From:
Sent: 26 December 2023 18:02
To: DCAdmin
Subject: Objection to 2023/62/93031/W Wappy Springs Planning Application

Cycle Kirklees (the Kirklees Cycling Campaign) promotes everyday cycling and is a membership organisation. We wish to object to this application (2023/62/93031/W). We contend that provision for walking and cycling to and from the site is inadequate and the applicant's transport report lacks the required elements that would make this accessible by non-drivers and comply with DfT guidelines.

Scale	Size	Date	Drawn	Checked
1:500	A3	DEC'22	MH	.
Status	<b>PLANNING</b>			
KPP Job No <b>2278</b>	Rev <b>A</b>	Number <b>2002</b>

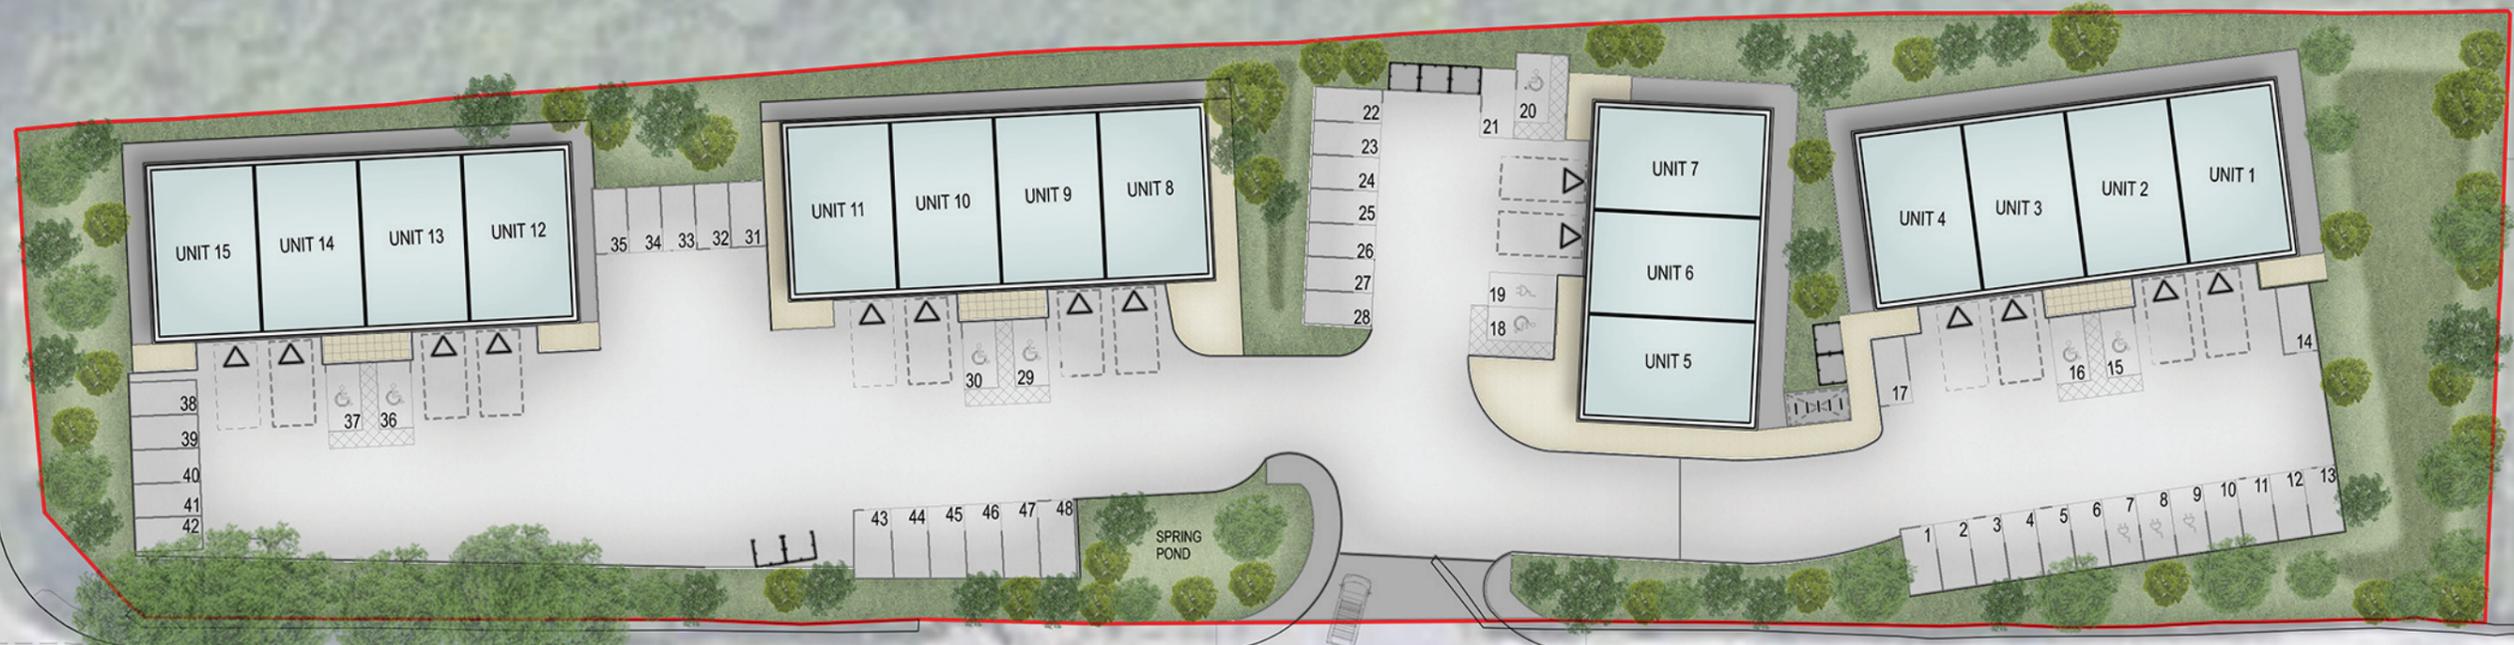
There are only a few uncovered cycle stands shown near units 4 and 5 whereas there is provision for car parking near all the units. Instead of the limited provision planned, to comply with current guidelines there should be sheltered cycles stands at each set of units.

Provisions in LTN 1/20 recommends 1 bicycle parking space per 500m². With a projected 8366m² floor space, we propose 16 spaces – making a set of 4 covered Sheffield stands outside each building.

Whilst the cycle parking that is included in the plans does meet the guidance for distance to the building entrances for units 1-8, we consider that additional spaces that should be provided to cater for for all units. Recognising the layout of the development, guidance recommends cycle parking is less than 100m from a destination. We would recommend dedicated facilities are placed outside each building. There should also be 5% for disabled cycles (1 space) which would need to go next to the disabled bays, but if all cycle parking was located just outside the entrances, we suggest that would be sufficient.
